From: Paul Troop <pault@gclaw.co.uk>
Sent: 02 July 2020 15:10
To: Richard Cutler; White, Joy - Communities; Caroline Ford;
Rashid.Bbosa@Oxfordshire.gov.uk
Cc: George@BicesterBUG.org; rick@BicesterBUG.org
Subject: Comments on 20/00293/OUT

Bloombridge have uploaded a helpful outline of the planned access for the above development (drawing 46463/5501/001, Revision B). We have some brief comments:

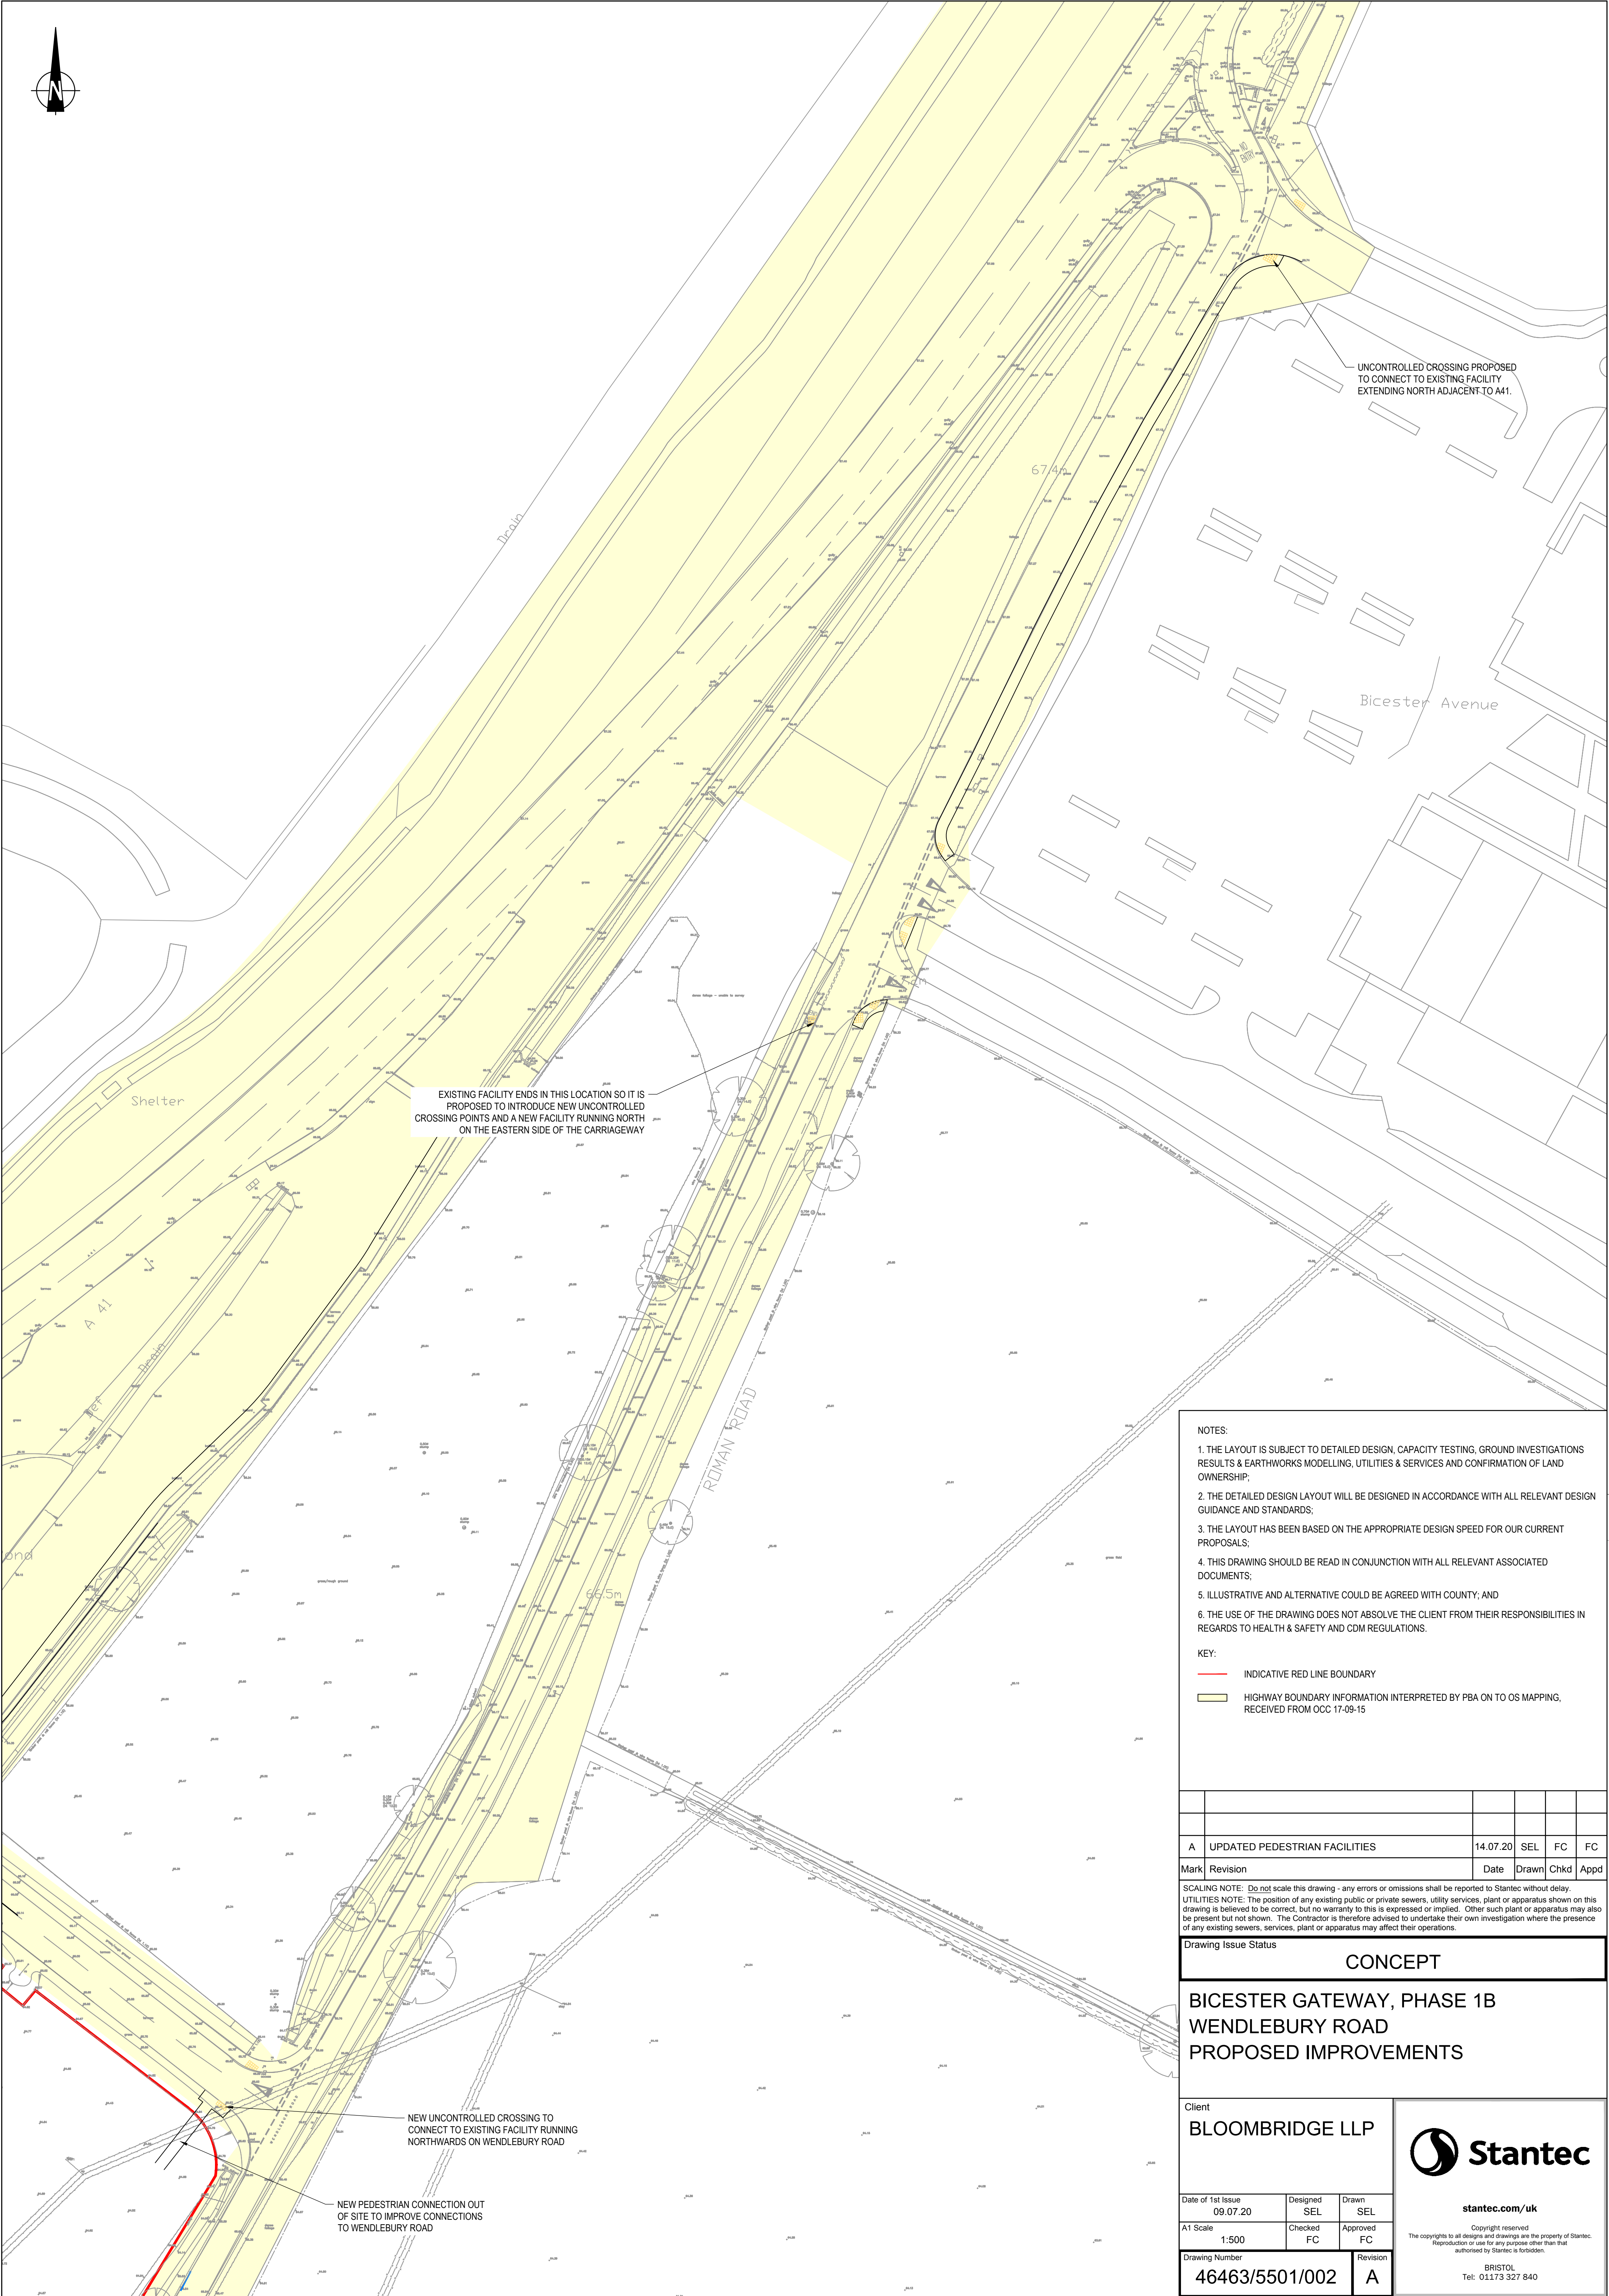
1. We assume that a parallel crossing at the Vendee Drive roundabout is not technically feasible, presumably due to the speed limits and / or visibility necessary, though we have not been provided with the technical report. However, there are positive aspects to the current crossing. In particular the reduction from 3 to 2 lanes on the south side will reduce the distance needed to cross, and will therefore make the crossing safer. The wider splitter island is also now wide enough to accommodate the cycle design vehicle.

2. The provision for a shared pedestrian and cycle path on the south side of Charles Shouler Way is a positive step. However, we query why this is not extended along the length of Charles Shouler Way. In addition, the safety and usability of the shared path would be significantly improved with horizontal separation from the carriageway. DMRB CD195 Table E/3.26 recommends separation of 1m in a 40mph area. Therefore at least 4m should be allowed. While the shared path now diverts away from Charles Shouler Way to direct pedestrians and cyclists towards the crossing and splitter island, this effectively moves away from the desire line for those users intending to use Charles Shouler Way. We suggest that a shared path is retained along the existing path to allow users to travel to Charles Shouler Way by the shortest distance. Finally, there seems to be no provision for cyclists to use the north side of Charles Shouler Way, only pedestrians. We feel this is not in accordance with the letter or spirit of the OCC Cycle Design Standards that require (1) either separate paths for pedestrians and cyclists, or (2) a shared path. Again, we would suggest that horizontal separation is necessary here as well as the retention of the previous shared path for users heading south on the A41 shared path and intending to travel along Charles Shouler Way.

3. We commend the upgrading of the currently obsolete A41 overpass for pedestrians and cyclists. This should discourage anti-social behaviour and provide a route for users of the Phase 1B facilities to access Chesterton and vice versa. However, we doubt that the overpass will become a preferred route for those using the NCR, not least because it requires cycling up a hill in both directions to use it. We maintain that users of the NCR will continue to prefer to use the Wendlebury Road.

4. We remain concerned about the lack of desire to provide any pedestrian or cycling provision along the route of the NCR on Wendlebury Road. At the very least, a shared crossing from the Wendlebury Road south to the existing shared path on the Wendlebury Road north needs to be provided, ideally with a splitter island.

5. We note that a 40 mph limit is to be introduced, but we still feel that a 30mph for what will become a single carriageway urban residential area would be more appropriate.
